Planning Department
Kirklees Council
Via email

RE: 2026/62/90232/W | Marsden New Mills, West Yorkshire, West Yorkshire, HD7 6AZ. Application for demolition, redevelopment and associated landscaping. Conversion of site to residential and commercial uses.

The Victorian Society

## Landscape Masterplan - Phase 1

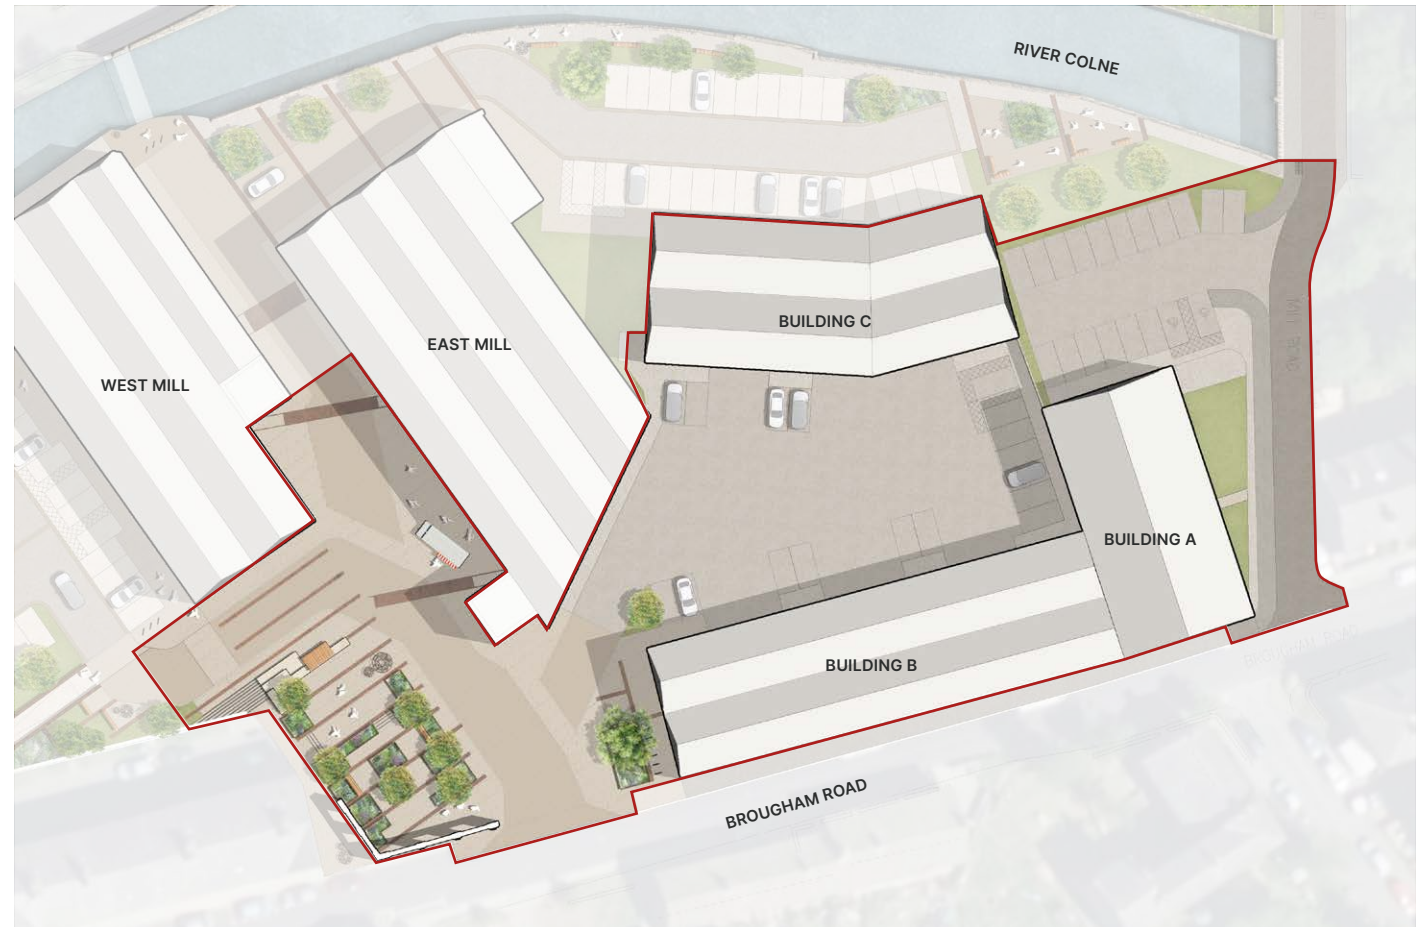
Discussions were held surrounding the car-central nature of the proposals. Given that ~40% of global carbon emissions are released by the demolition, construction, retrofitting and running of buildings, and this application will certainly release a great deal of embodied carbon, we suggest that the proposals are reconsidered to allow for more public transport and light-weight transport, such as bicycles. We accept that some carparking provision will be required, but the current proposals are heavily car-centred and will neither preserve or enhance the Conservation Area.

The landscaping is also uninspired and unsympathetic and does not compliment the wider historic context of the site. Further provision of green public spaces would help lessen the carbon impact of the works and encourage the use of public space.

## Opportunities

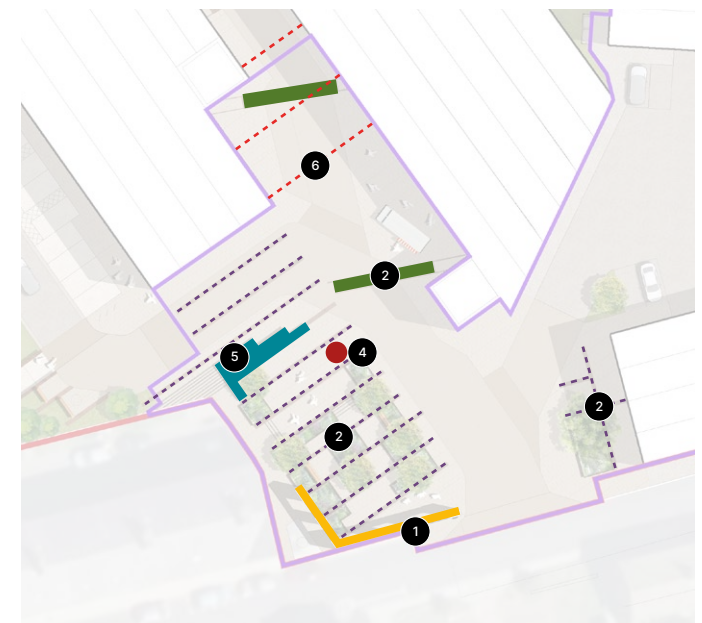
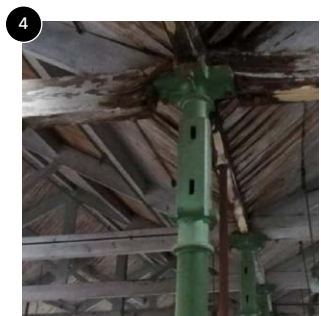
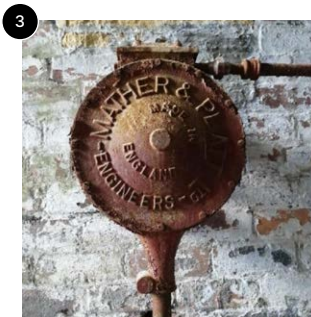
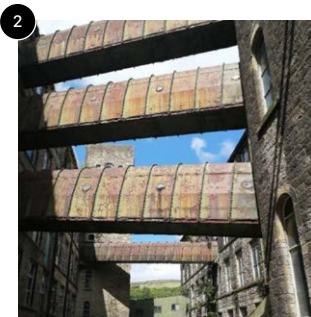
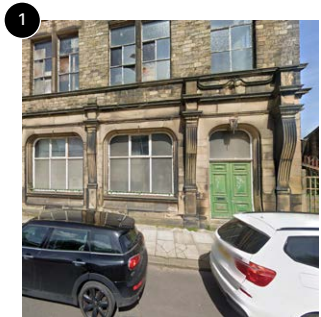
The Victorian Society is deeply concerned by the extensive level of demolition at the site, and the loss of substantial heritage buildings of high significance. Of particular concern is the loss of the former Wages Office, the loss of which the Society strongly objects to, and a building which the application describes as being of '*Phase 1*' construction (mid-late C19th), despite the heritage statement describing that the proposal '*retains all of the surviving Phase 1 fabric*' (page 41). We object to the demolition of this building, as an example of the earliest phase of development at the site, and question how 'surviving' fabric has been decided.

We understand that the justification for the demolition of the former Wages Office is to create new access routes. The Society emphasise that this is not adequate justification to demolish a building of this architectural calibre, and that the proposed access routes should be routed or traced around the heritage buildings – especially since these routes do not exist yet and are easily moved on paper at this stage.
